**Lead Local Flood Authority**  
**Post Point CHN 215**  
**Hertfordshire County Council**  
**County Hall, Pegs Lane**  
**HERTFORD SG13 8DN**

Date 26 April 2023

**RE 6/2022/01853/MAJ - Eisai Europe Limited, European Knowledge Centre,  
Mosquito Way, Hatfield, AL10 9SN**

Appendix D Drainage Layouts

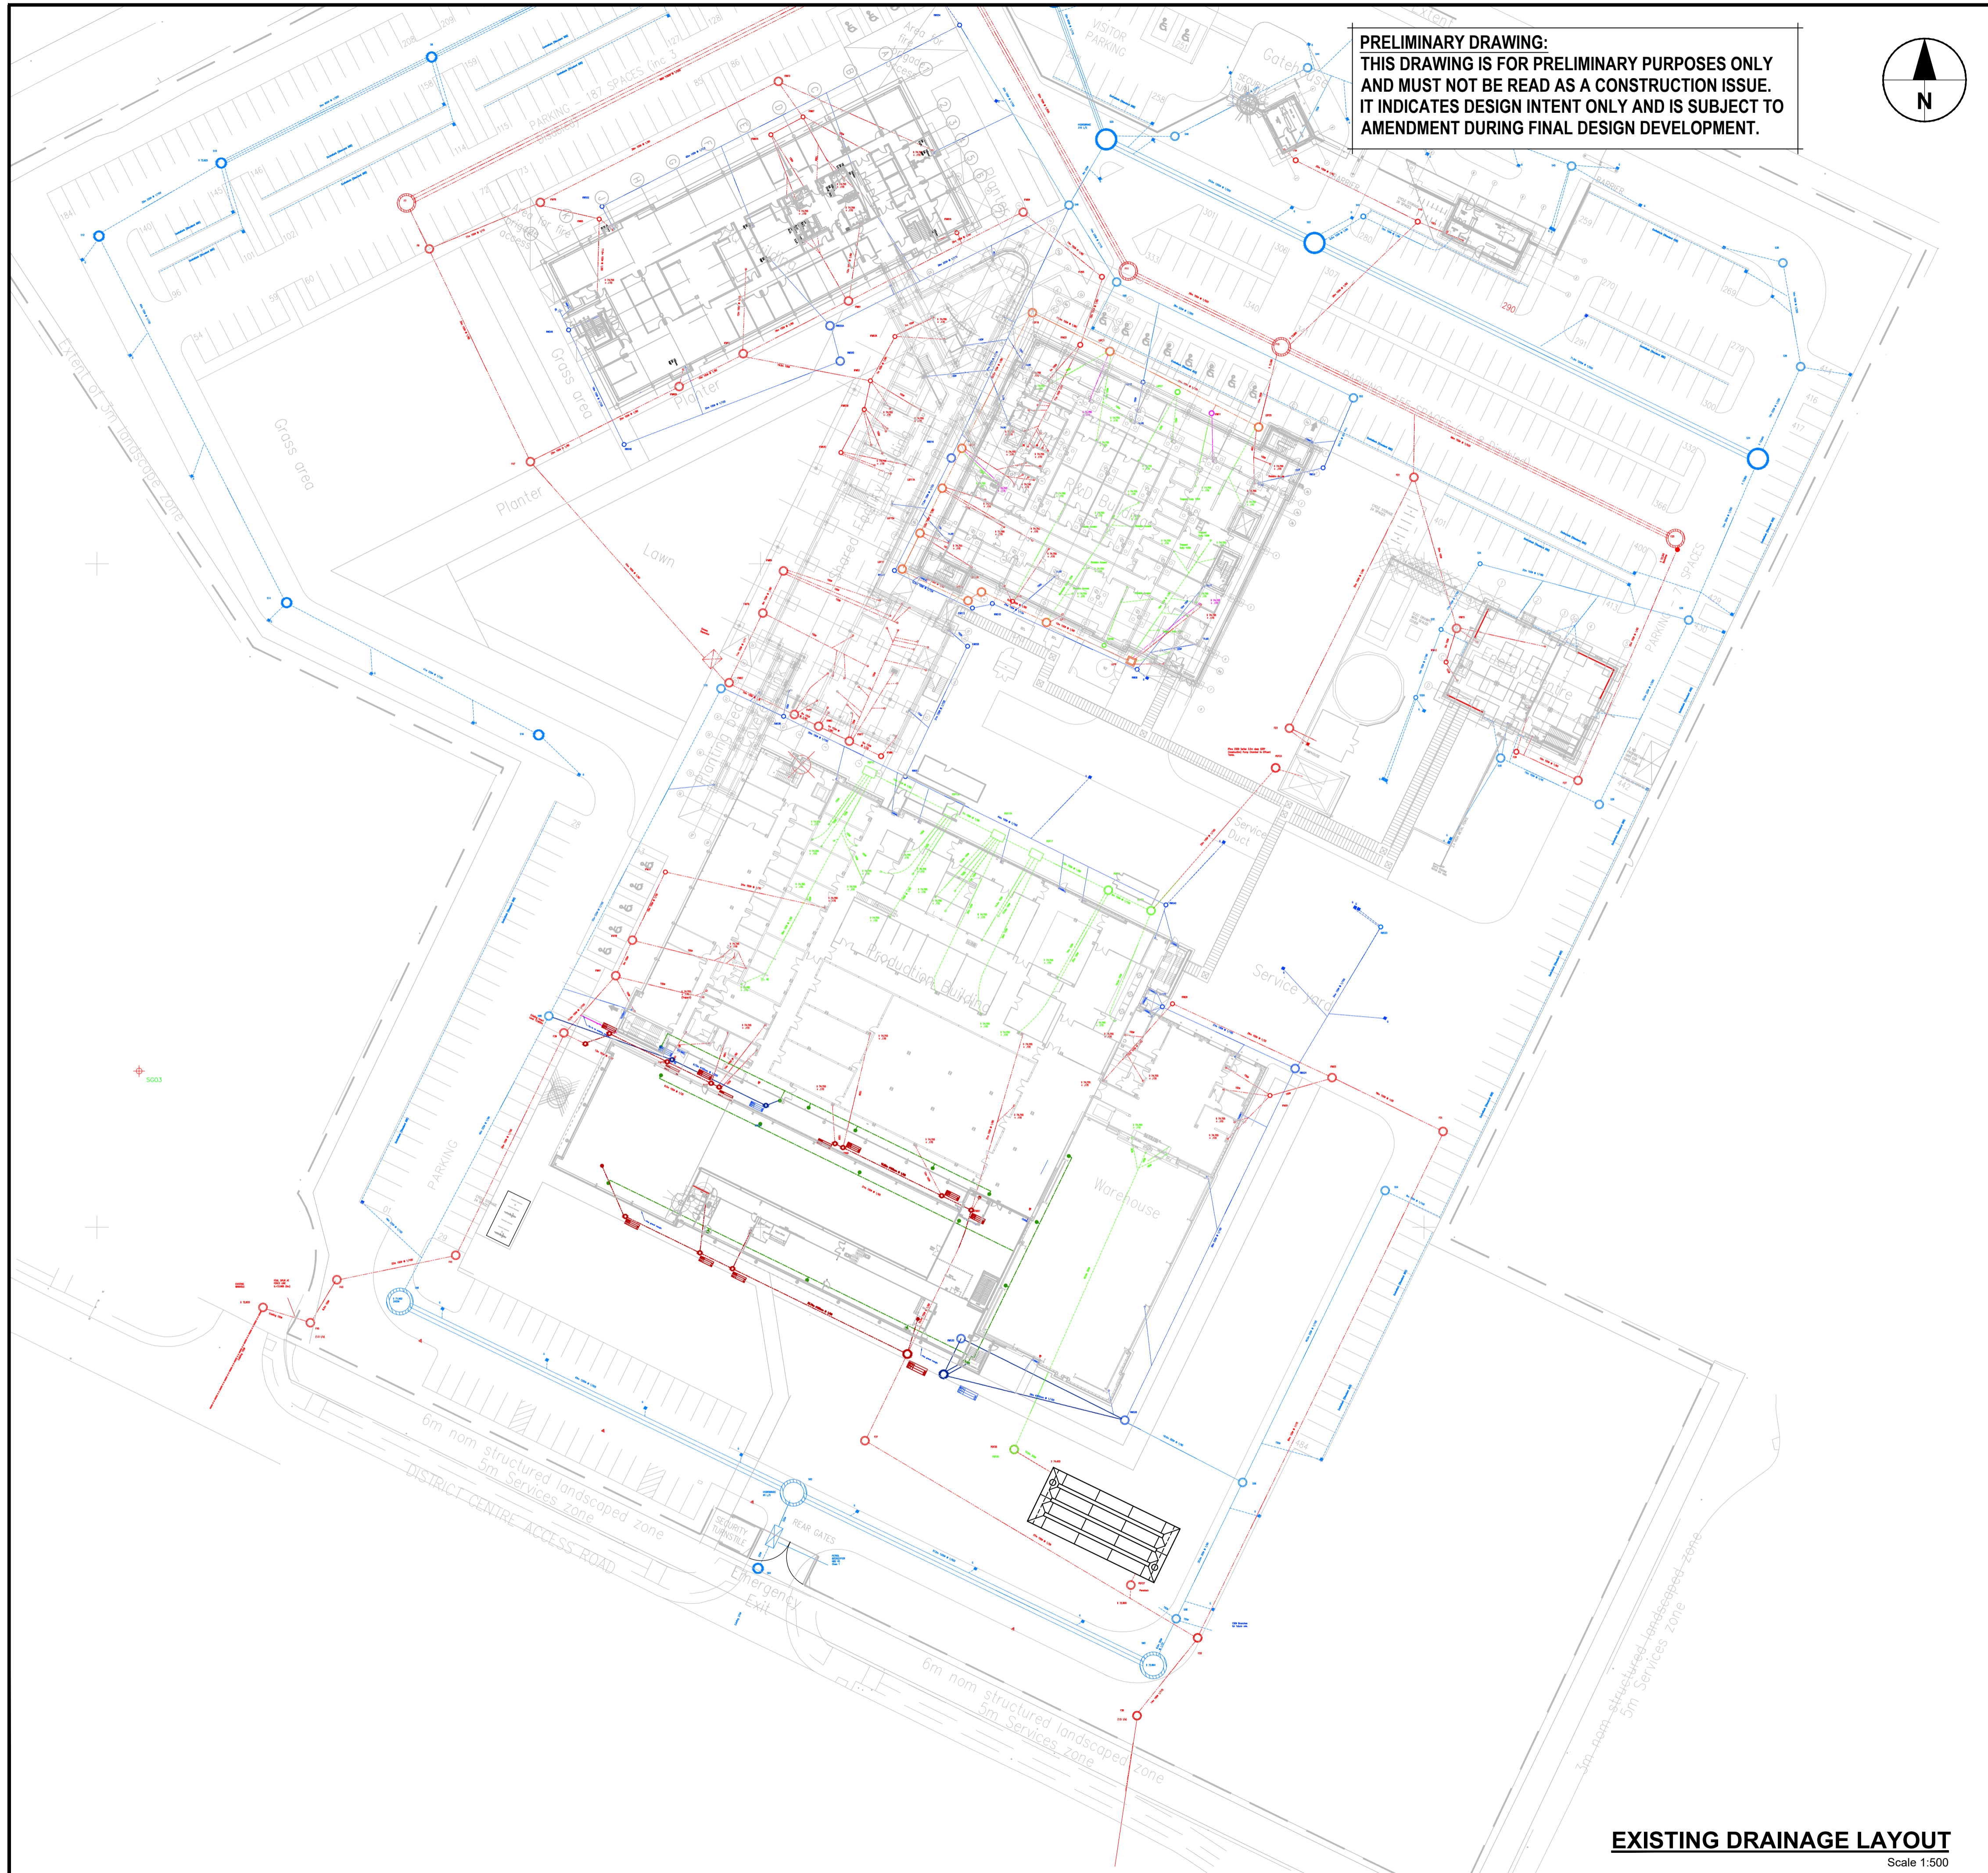
- d. A full detailed drainage layout plan showing the proposed SuDS features, any associated manhole cover and invert levels, proposed ground levels, pipe sizes and gradients, all online controls, online and offline storage structures, water quality mitigation and outfall details has been provided however, based on the proposed phasing plan (Drainage Strategy Figure 2-3) it is unclear whether all relevant areas are included in the proposals in the Appendix D. We await clarification and recommend an impermeable areas plan is prepared.

SHEET TITLE
EML FACILITY EXPANSION
PROPOSED SURFACE WATER
DRAINAGE LAYOUT
OPTION 2

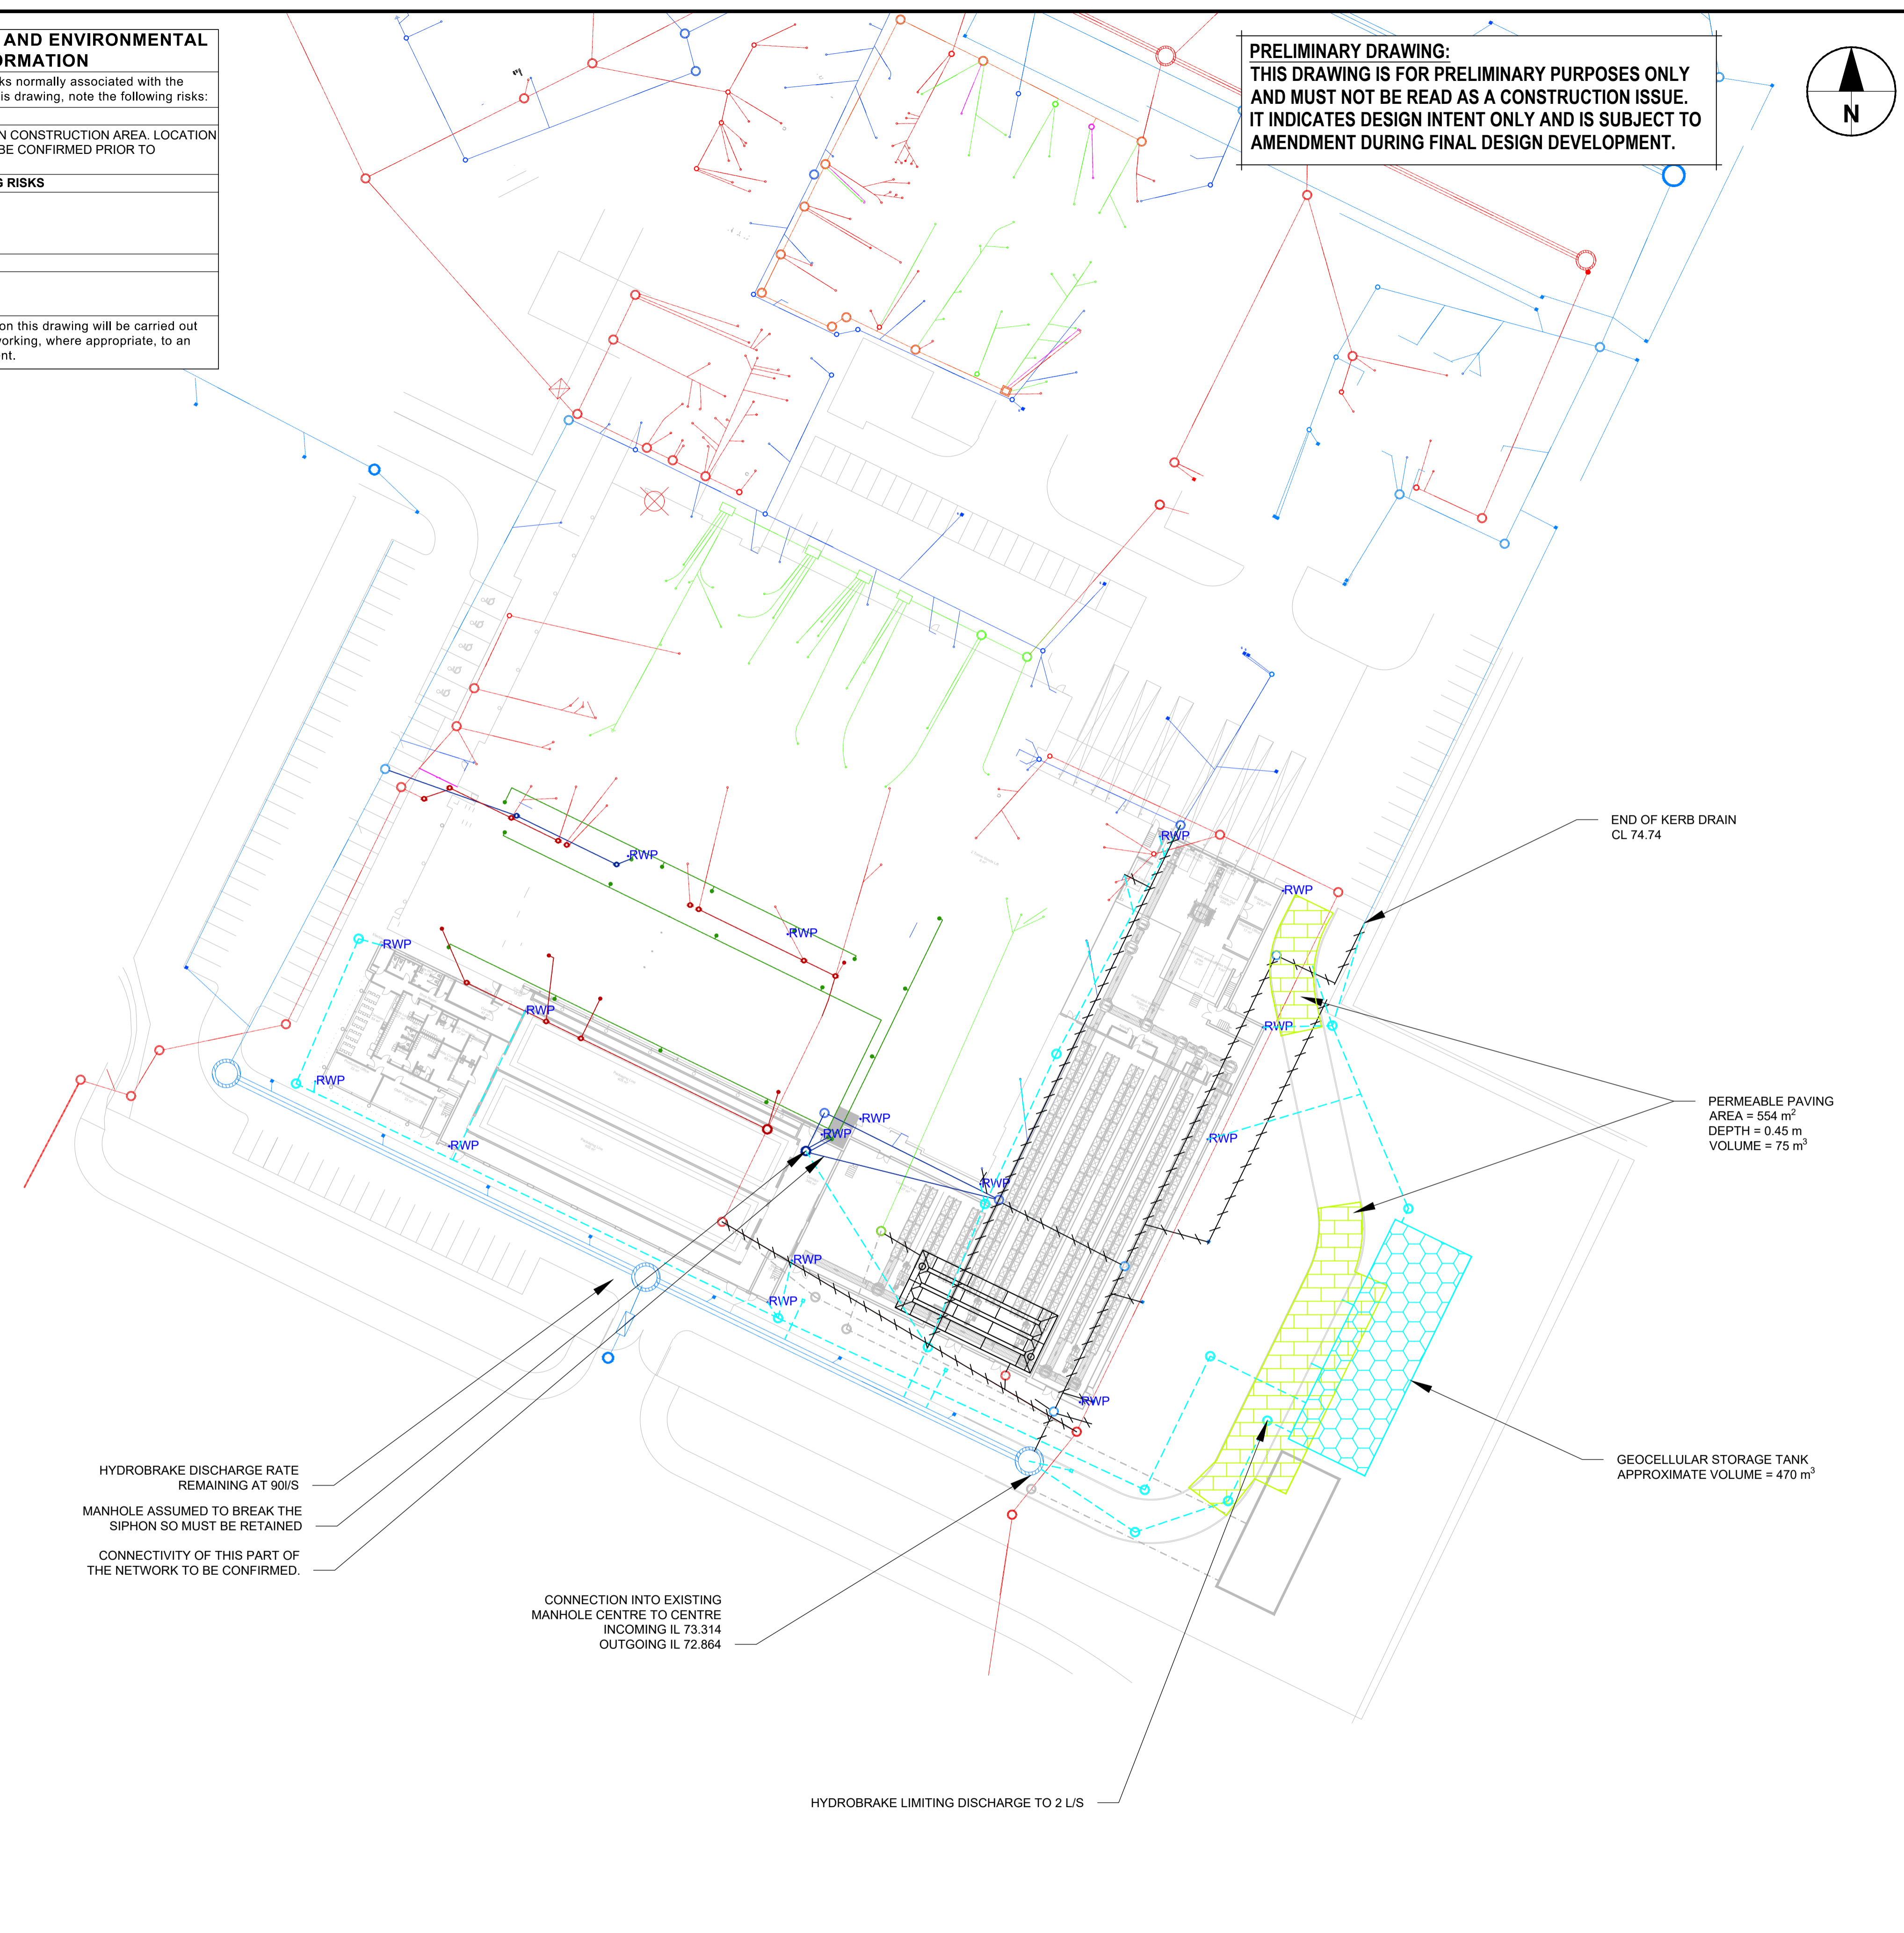
- e. Provision of supporting calculations to demonstrate there is no flooding of the drainage network at the 1 in 30 year rainfall event and that no flooding occurs of building at the 1 in 100 year plus climate change event. All supporting calculations and modelling scenarios should use FEH2022 rainfall parameters and include a summary of results, showing all the modelling criteria and summary network results for critical design storm events. The results will show maximum water level, flow and velocity. Currently, the calculations have used the outdated FEH and are only provided for the 1 in 2 year, 1 in 30 year plus climate change and 1 in 100 year plus climate change. We require the standalone 1 in 1 year, 1 in 30 year and 1 in 100 year in addition to those previously mentioned. We also require pipe lengths to be included in the calculations to be able to correlate with the drainage drawing to ensure the system, is not over or underestimating storage. We await further information.

- f. The applicant shall provide comment to demonstrate as to how freeboard has been provided to any finished ground floor levels of buildings or essential infrastructure (e.g., plant rooms). This shall be added to the drainage drawing. We await further information.

5. We require clarification on why the permeable paving along the road is broken up into two sections given the topographic survey does not highlight any steep area. We require justification why permeable paving cannot be used throughout the whole of the proposed internal road to add an additional layer of treatment. We require the application to provide clarification on the levels of treatment for the proposed road which ties into the existing road to the west and south of the site.
